**SUBMISSION BY
RESIDENTS OF MEDWAY AND SURROUNDING PROPERTIES
IN RESPONSE TO**

BERRIMA COLLIERY PROJECT MP10_0172

***APPLICATION DA No. 401-11-2002-i MOD 6
BERRIMA CEMENT WORKS SECTION 75W MODIFICATION OF EXISTING DA IN
RELATION TO COAL STOCKPILING***

MEDWAY GROUP

FIGURE 12.1  
Noise monitoring locations

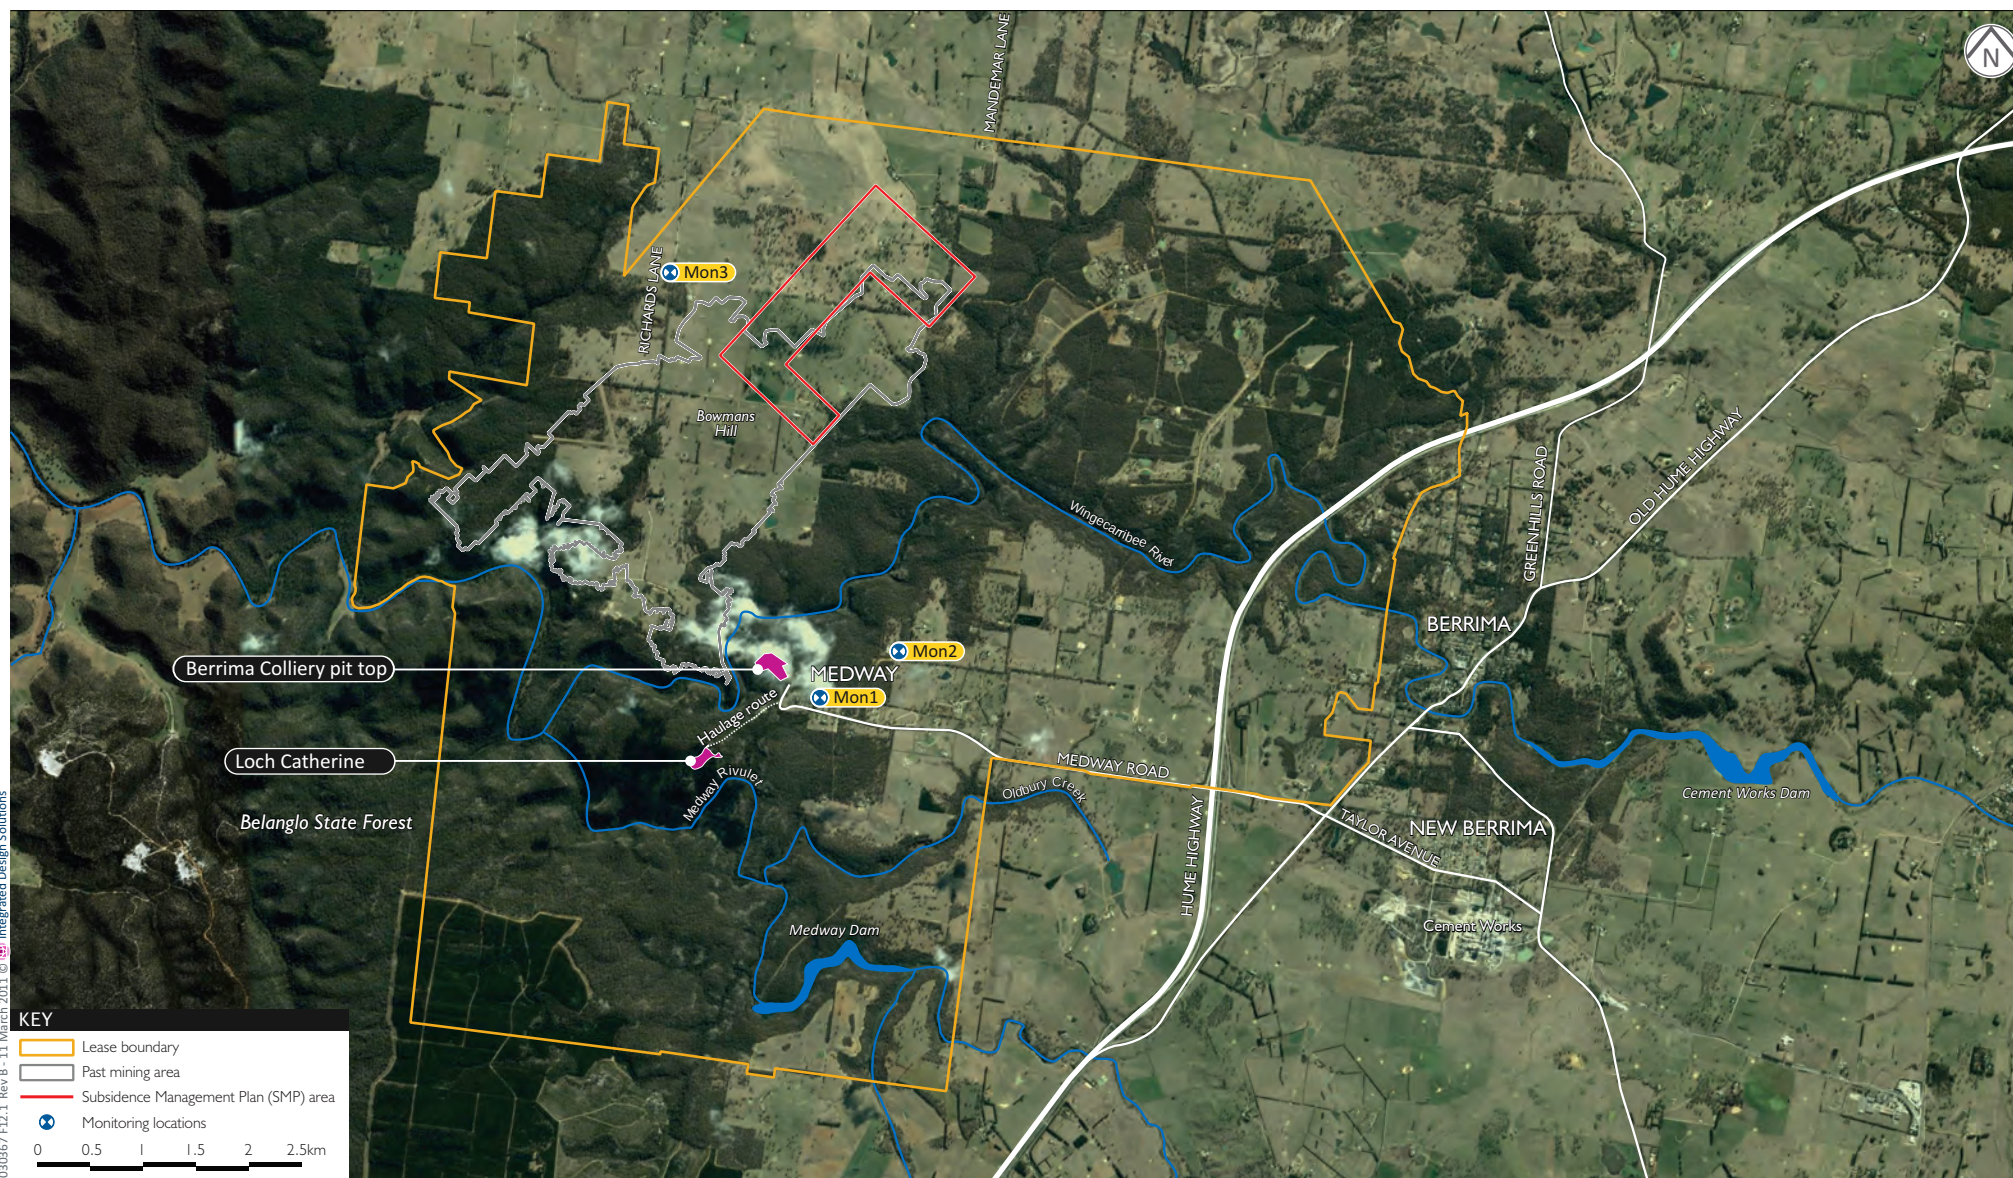
Boral noise monitoring locations (EA Appendix G, fig 2.1) do not adequately assess the impact on the most noise-exposed residents. The placement of the monitors can in no way accurately assess the impact on those most affected as they are too far removed to provide adequate readings.

Monitors should have been placed in properties directly fronting Medway Road and close to the entrance to Loch Catherine.
